## Response to Comments

Project Name: 163 RV storage  
 Project File Number: PreApp 23-007  
 Review Completion: March 23, 2023

ADMINISTRATIVE SITE PLAN

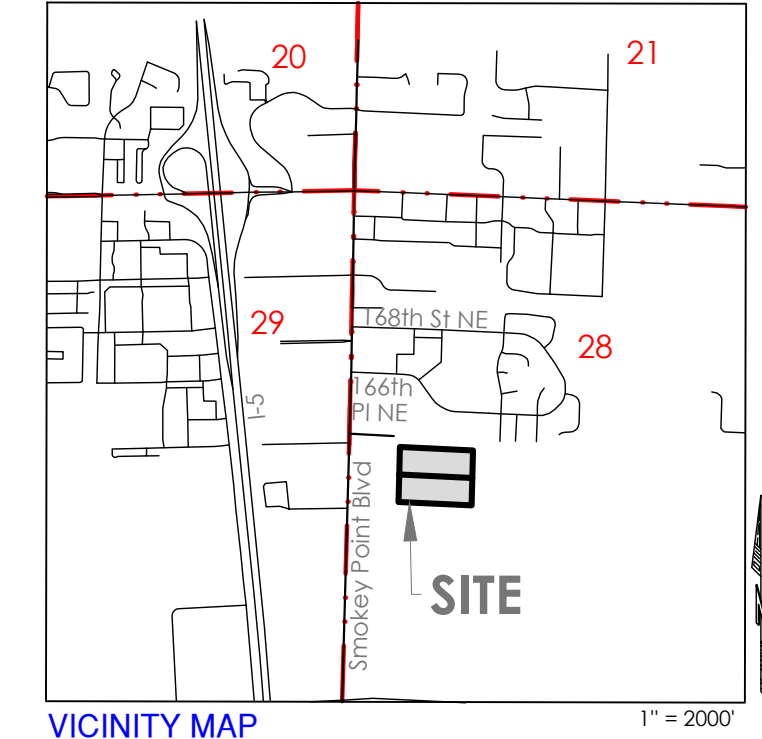
CITY COMMENTS	LAND TECH RESPONSE
<p>be seen from any point beyond the outside of the property.</p> <ul style="list-style-type: none"> <li>The storage and handling of inflammable liquids, liquefied petroleum, gases, and explosives shall comply with rules and regulations falling under the jurisdiction of the city's fire chief, and the laws of the state of Washington. Bulk storage of inflammable liquids below ground shall be permitted, and the tanks shall be located not closer to the property line than the greatest dimension (diameter, length or height) of the tank.</li> <li>Provisions shall be made for necessary shielding or other preventive measures against interference as occasioned by mechanical, electrical and nuclear equipment, and uses or processes with electrical apparatus in nearby buildings or land uses.</li> <li>Liquid and solid wastes and storage of animal or vegetable waste which attract insects or rodents or otherwise create a health hazard shall be prohibited. No waste products shall be exposed to view from eye level from any property line in an industrial district.</li> </ul>	<p>Generic note provided on Site Plan, although does not seem relevant.</p> <p>Generic note provided on site plan, P1.</p> <p>Generic note provided on site plan, P1.</p>

10. Emergency access to locked gates shall be provided for firefighting operations by use of approved Knox products (IFC 504/506).	Understood, note added to plan.

11. Hazardous materials storage will not be allowed without meeting additional requirements	Understood, note added to plan.
